From: Erin Moore
Sent: Friday, June 14, 2013 9:35 AM
To: Jeff Watson
Subject: FW: Kittitas County Notice of Application AU-13-00003 Lund

The comments from the Kittitas County Public Health Department are as follows:

LUND SITE PLAN, 3802 CARIBOU RD

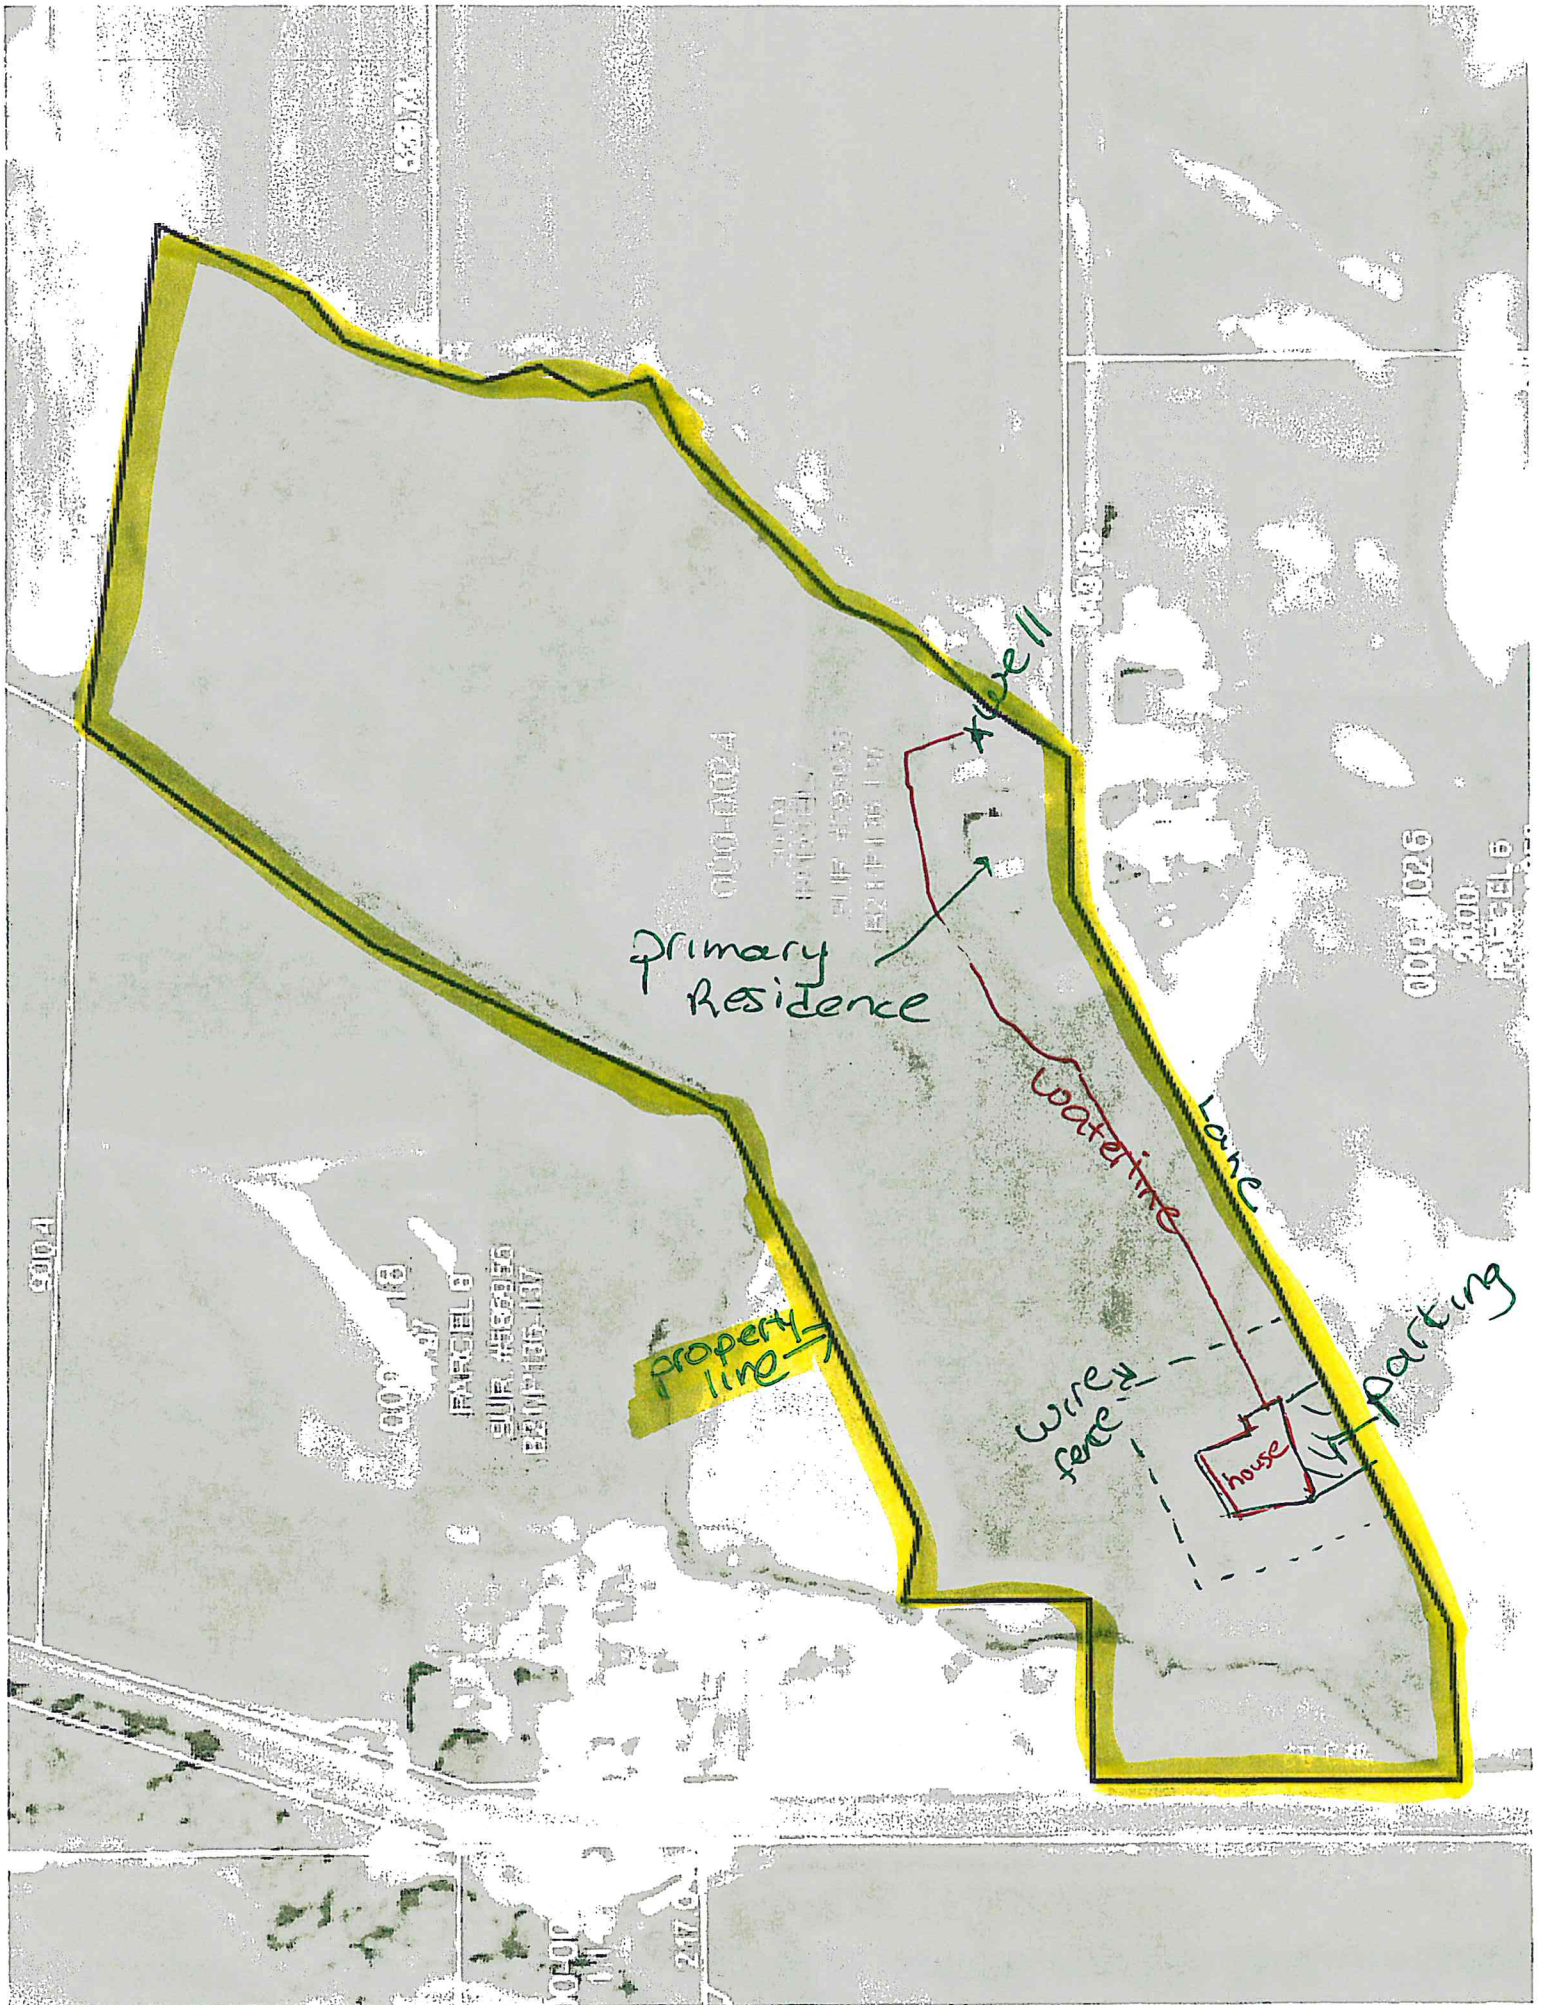
Water- none
OSS- Needs a new septic system and reserve area for the proposed ADU.
